Recommendation Report for Planning Permission for Works or Extension to a Dwelling

REF NO: K/53/21/HH

LOCATION: Rock Cottage
18 Coastal Road
East Presston
BN16 1SJ

PROPOSAL: Side extension with catslide roof and alterations.

21/4858 /4

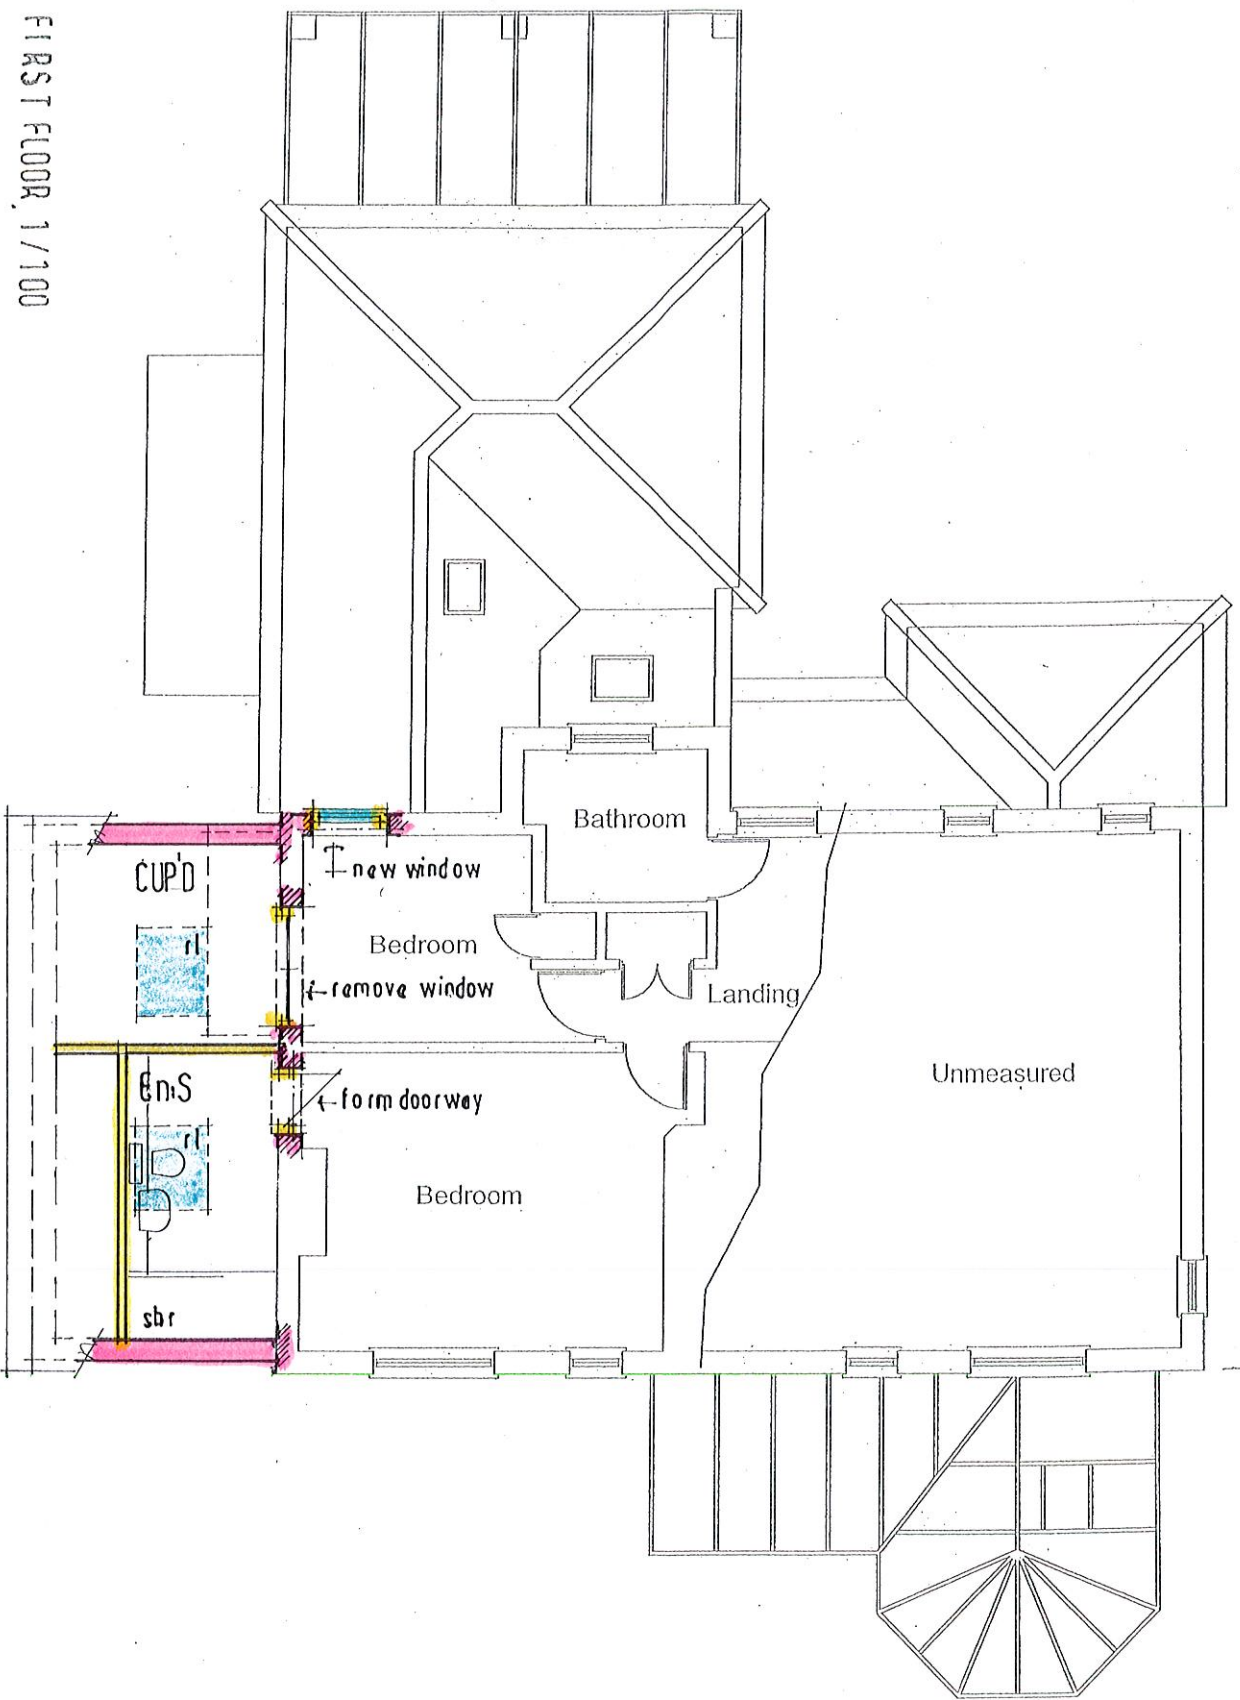
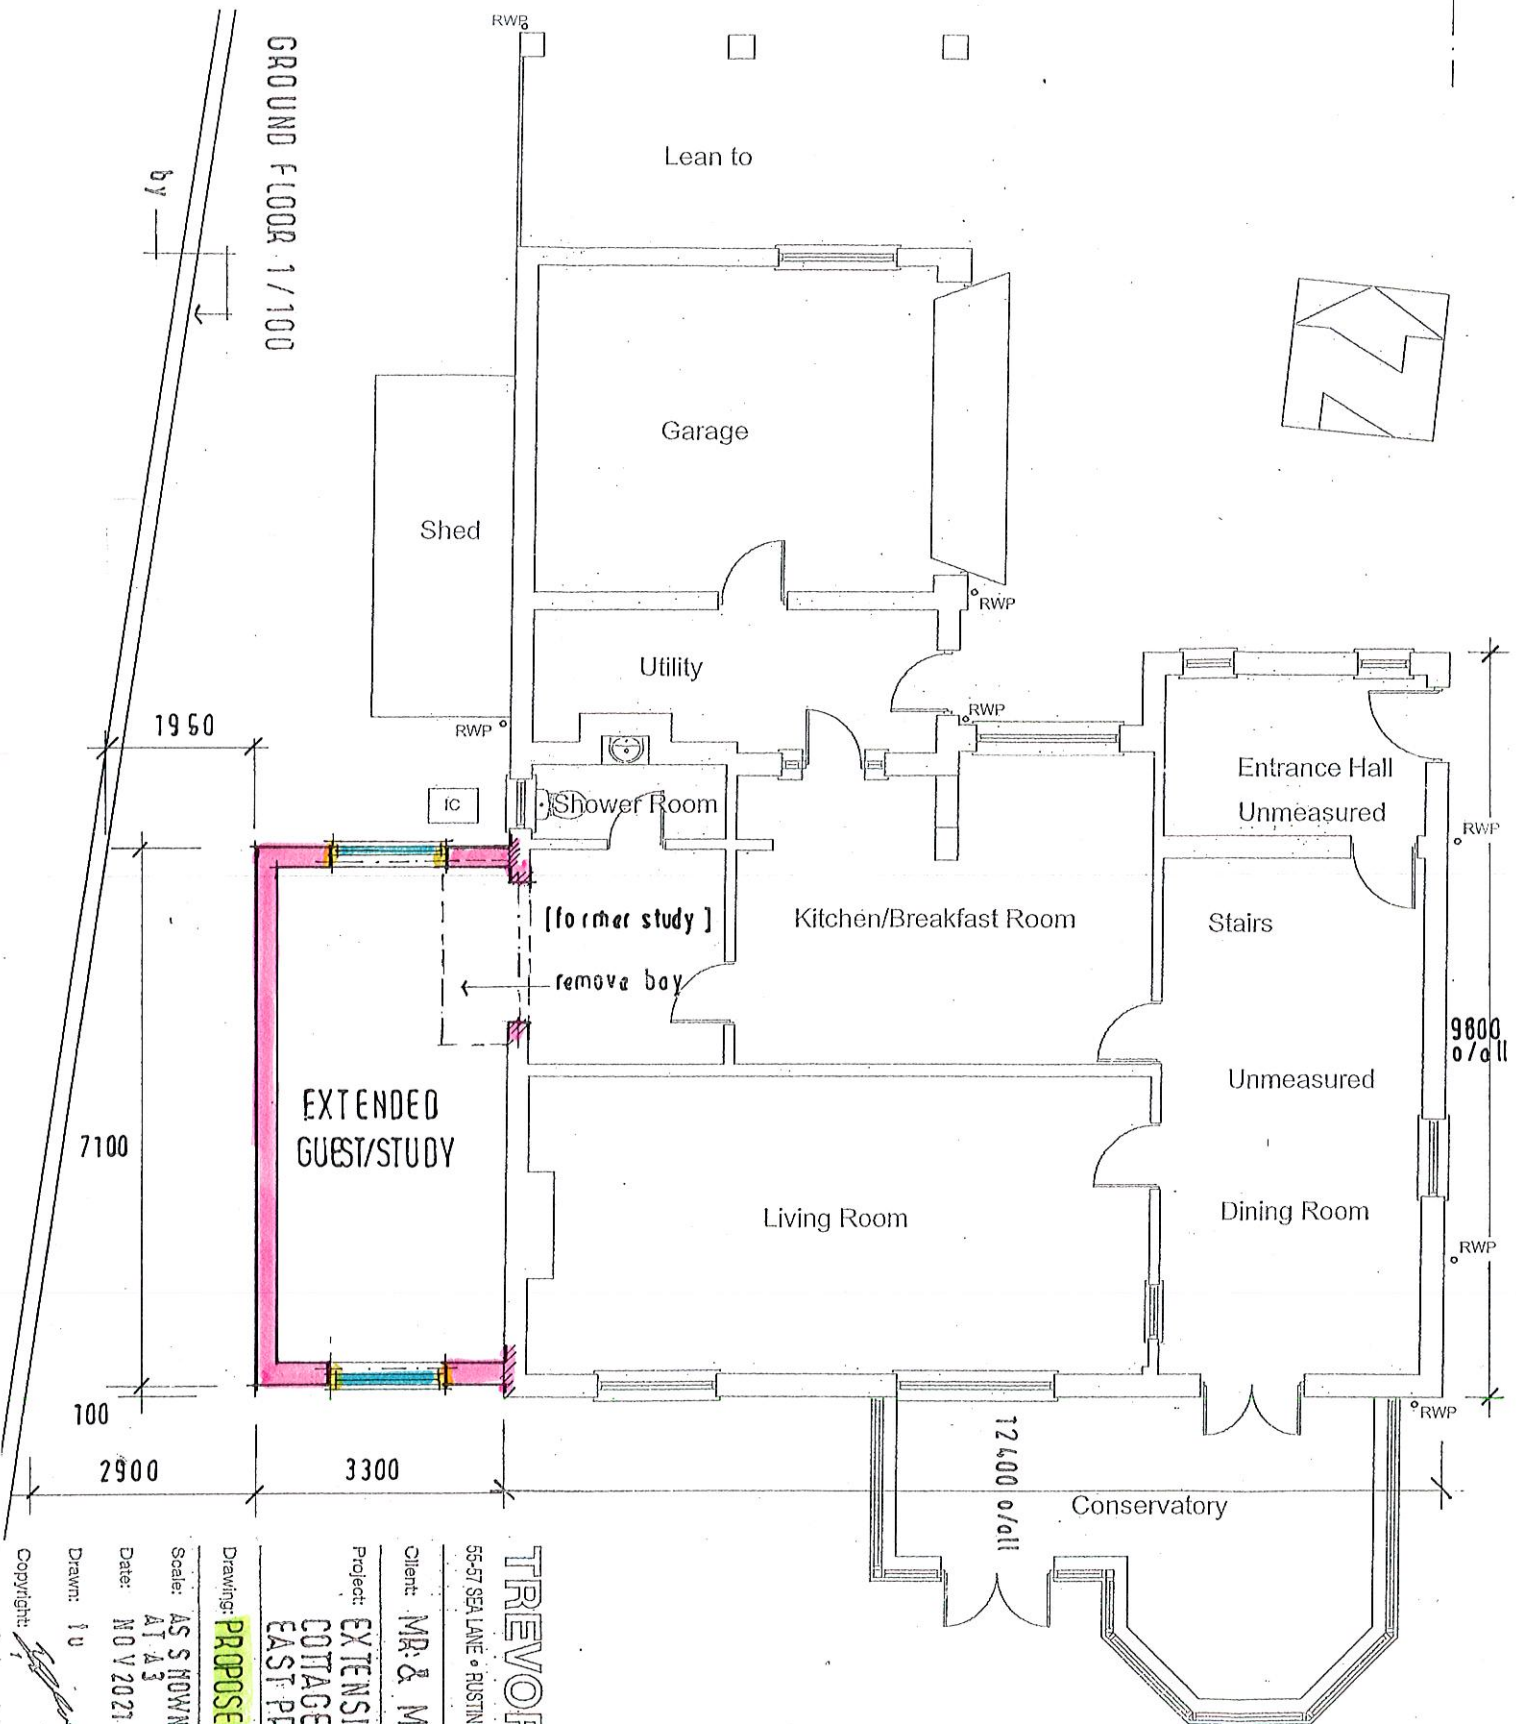
The proposal includes the addition of 2 No. rooflights and one ground floor front facing window. The front facing window does not give rise to any issue of overlooking. However, the proposed rooflights (servicing an ensuite and cupboard) are side facing and approx. 1.6m above finished floor level. Therefore, a condition has been attached to this application to ensure these windows are obscured up to 1.7m in the avoidance of adverse impacts on neighbouring properties by way of overlooking.

- 3 The 2 No. Rooflights on the western elevation of the proposal hereby approved shall at all times be obscure glazed to a minimum height of 1.7m from the finished floor level. The screening shall be retained in perpetuity.

21/4858 / 5

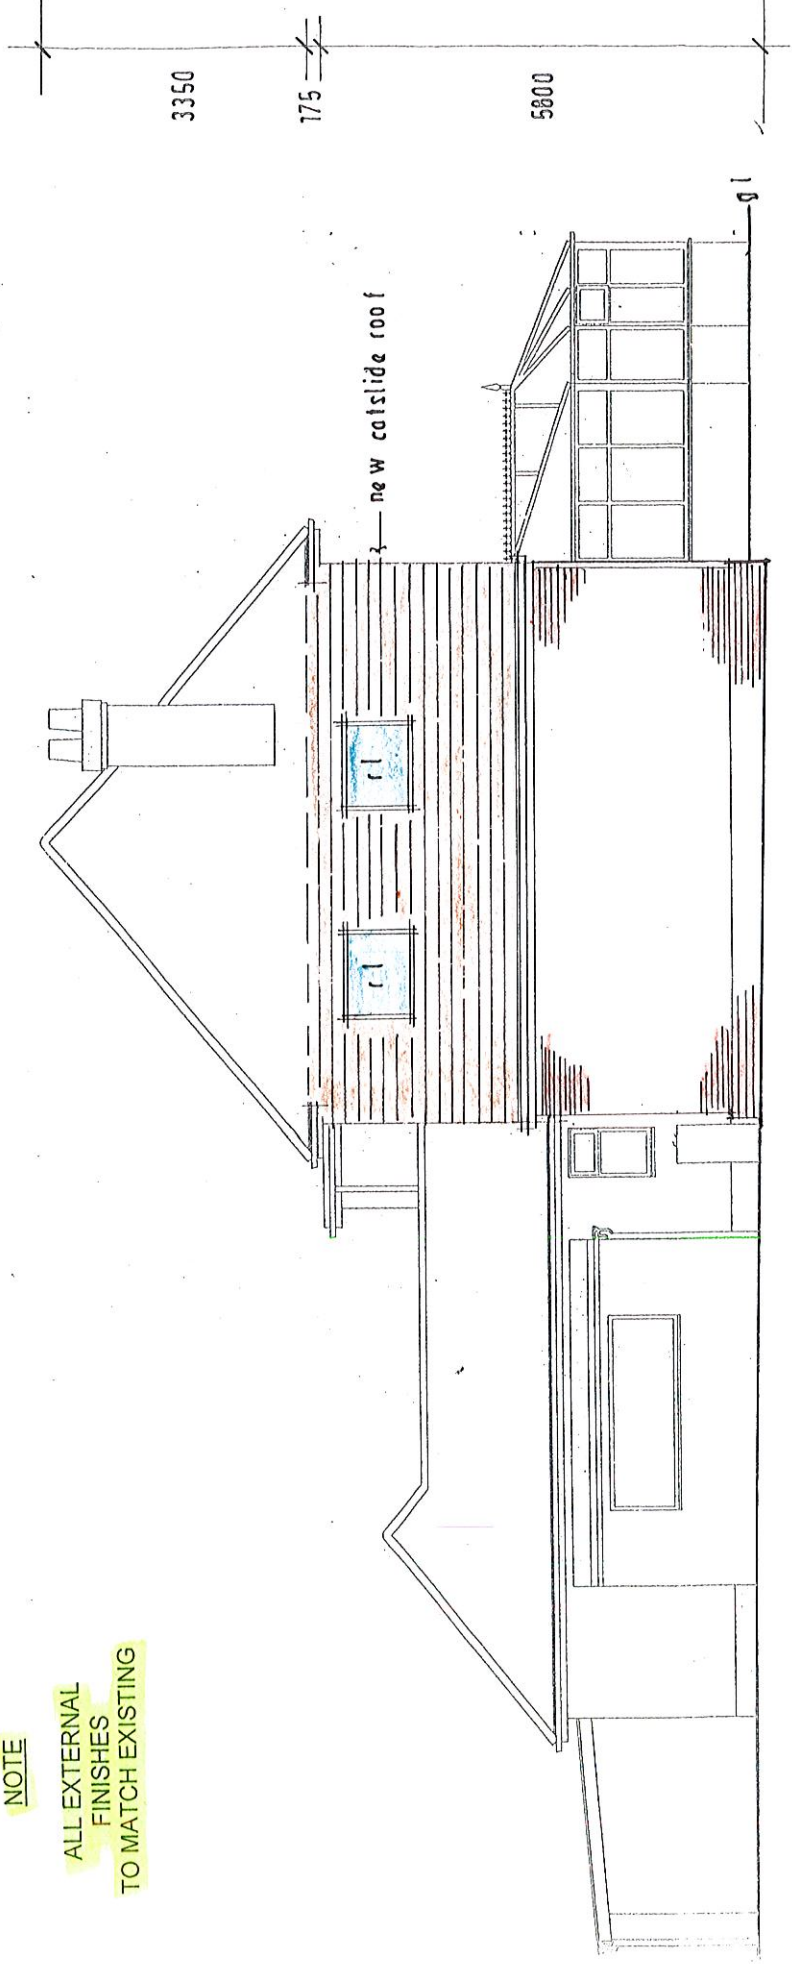
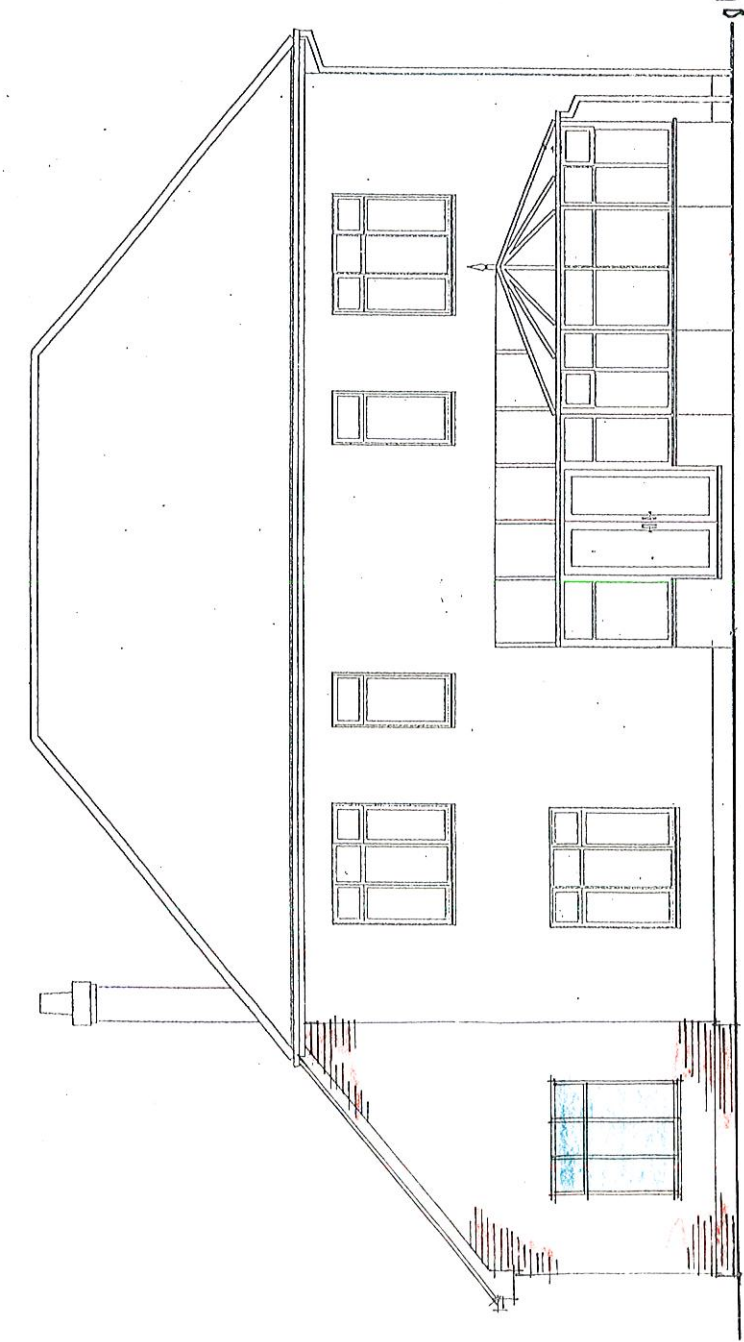
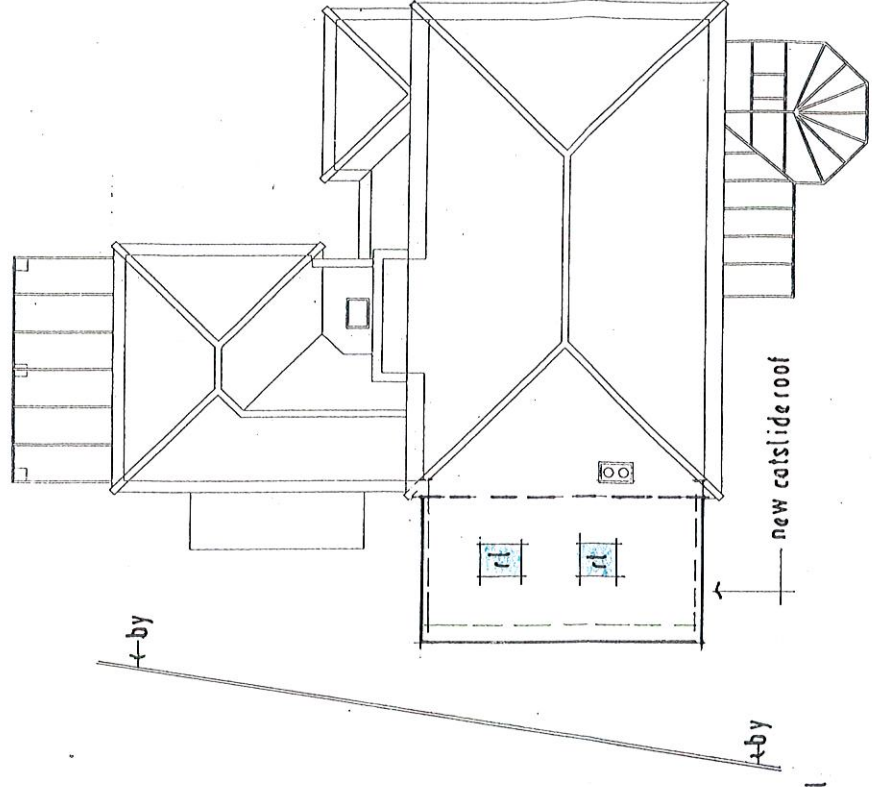
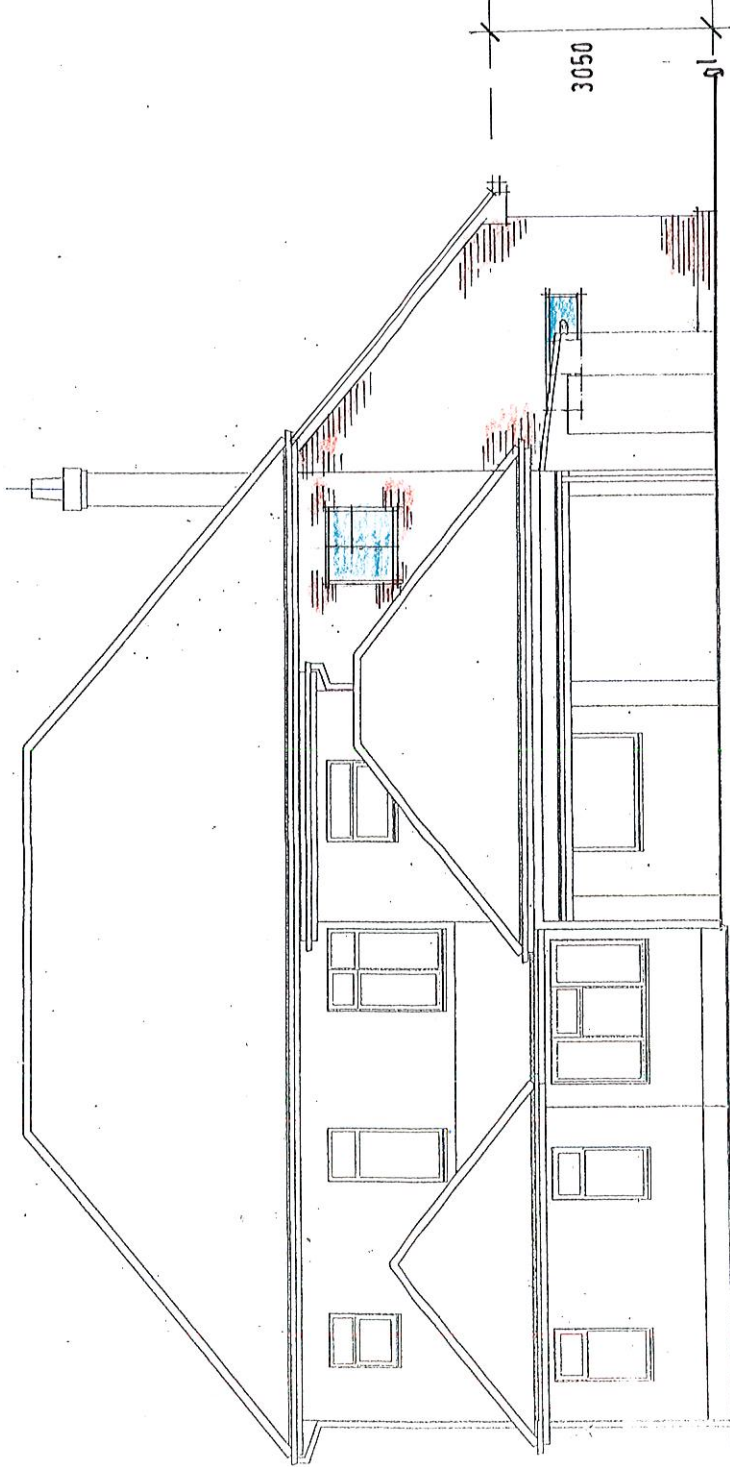
The host dwelling is a large two-storey detached dwelling. The proposal seeks to erect a two storey side extension that incorporates a catslide roof design that matches and meets the existing roof form. The proposal is approx. 7.3m in depth, approx. 3.3m in width with an eaves height of approx. 3.2m and overall height of approx. 5.8m. The proposal is large in scale but fits the form of the host dwelling well and is visually subservient to the host dwelling. The proposal meets the front elevation and is approx. 7.3m in depth, ending half way down the west elevation. The proposal is well integrated in terms of positioning. Section M of the Arun Design Guide regards proposals that incorporate a matching pitch to that which is found on the host dwelling as appropriate, as such the roof design of this proposal is appropriate. Furthermore, the proposal also incorporates the use of matching materials and as such is visually integrated into both the form and design of the host dwelling.

The extension does not obstruct any 45 degree sightlines of neighbour dwellings; it is well integrated in terms of sitting and form and retains approx. 2-3m of separation from the western site boundary. Furthermore, the catslide roof presents a sympathetic form with respect to sunlight availability of the western neighbour dwelling. Similarly the proposal is not overbearing and does not create overshadowing on neighbour dwellings.
